National Construction Code (BCA) 2013 Assessment Report

AXIS (STAGE 2) ***2 HERB ELLIOTT AVENUE, SYDNEY OLYMPIC PARK,*** ***NSW***

**Construction of a mixed commercial and retail development including
a two- level basement car park**

Date: *10 May 2013*

TITLE	1: 250	DRAWING NO.	DA-2-1002
DRAWN	DH	ISSUE	
CHECKED	AT	PROJECT NO.	090095
PROJECT NO.	090095		A

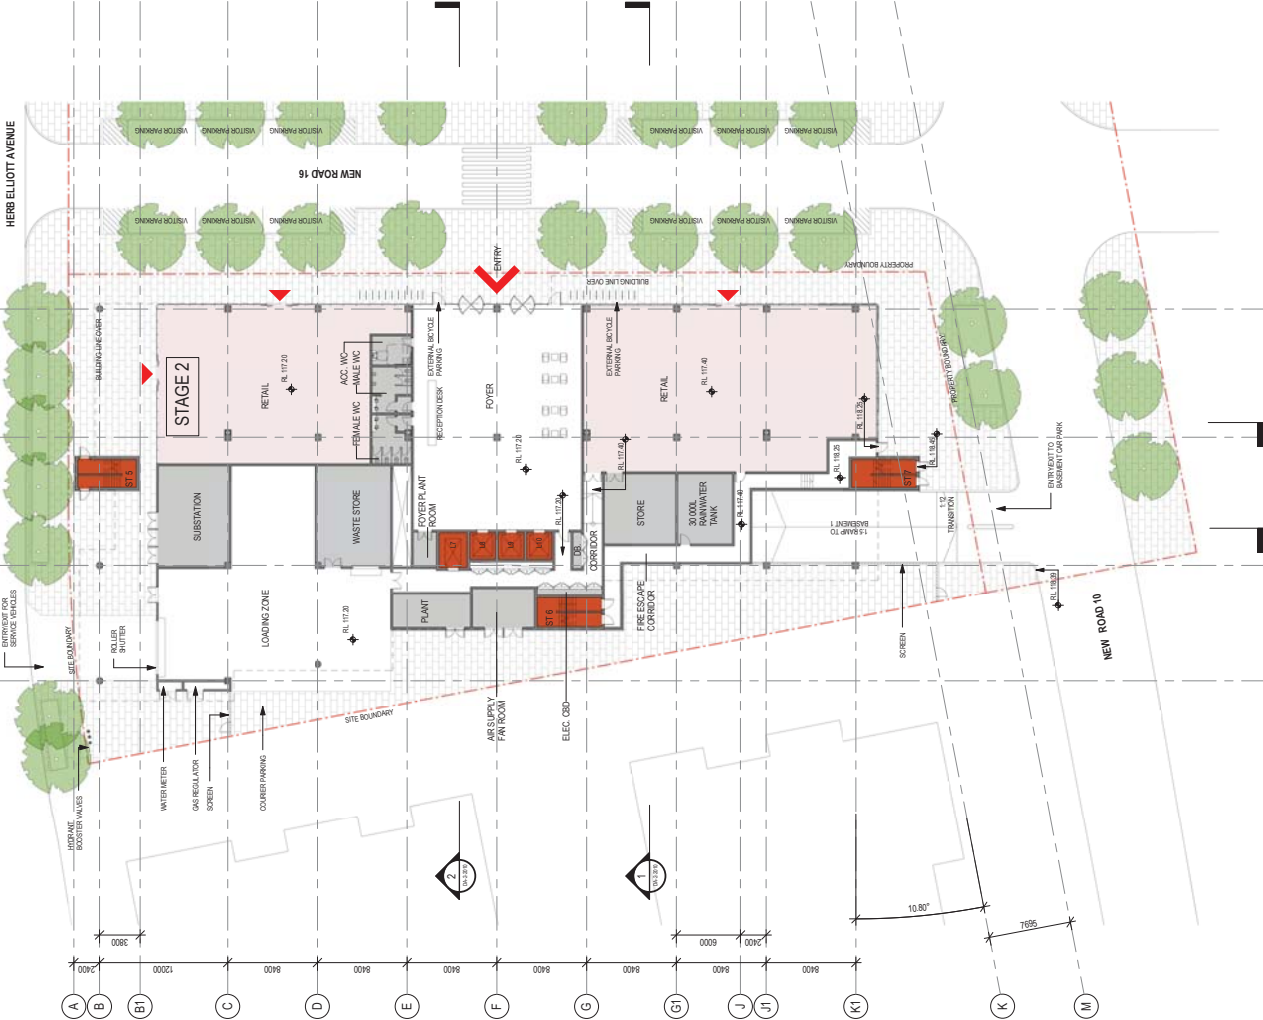
Your attention is drawn to ground floor level where the retail parts (being class 6) are situated either side of the commercial foyer, (being Class 5). Separating construction is evident from the plans assessed.

- Fire stairs ST5 and ST7 at the commercial levels, where there is the potential to divide the floors into separate tenancies. On this basis, there is a non-compliance relating to clause D1.7 (a)(ii) where the sole occupancy unit does not occupy the whole storey and an airlock or similar may be required.
- Fire Stair ST6 at ground level where the discharge point is into a 'covered area'

Compliance appears to be achieved with Fire Stair ST6 where the design at ground floor level appears to match Figure D2.4 of the Guide to the BCA (2012).

Your attention is drawn to the passageway from Fire Stair ST6 in this regard.

Scale	1: 250	Drawing No.	DA-2-1000
Drawn	DH/PA	Issue	
Checked	AT	Project No.	090095
Project No.	090095		A

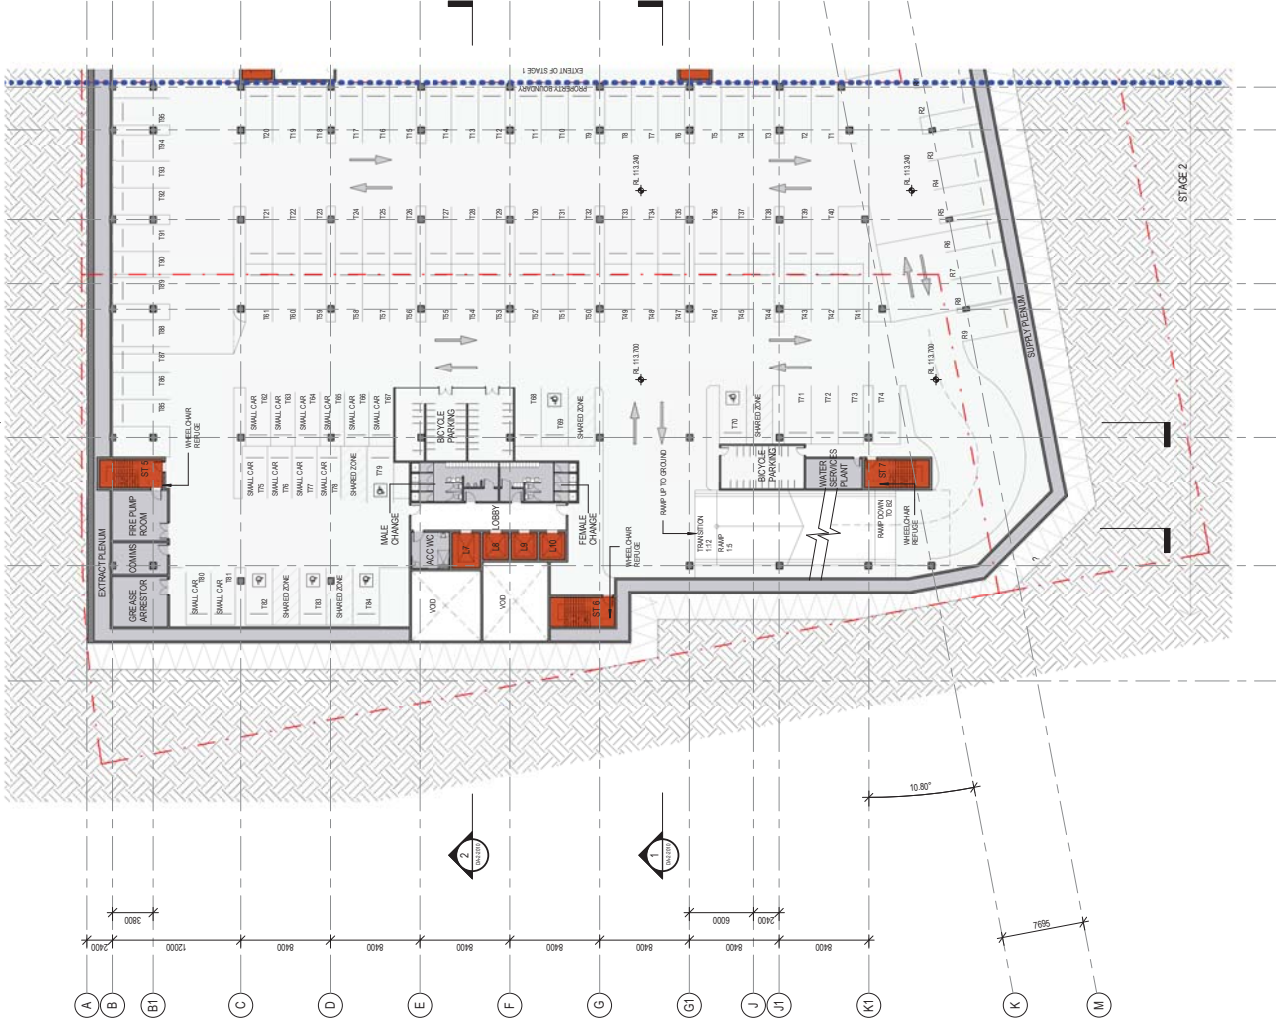
All exit paths to 'open space' are required to be 1m in width and bollards will be required to exit doors that could be blocked by vehicles on the basement car parking levels. Please confirm compliance.
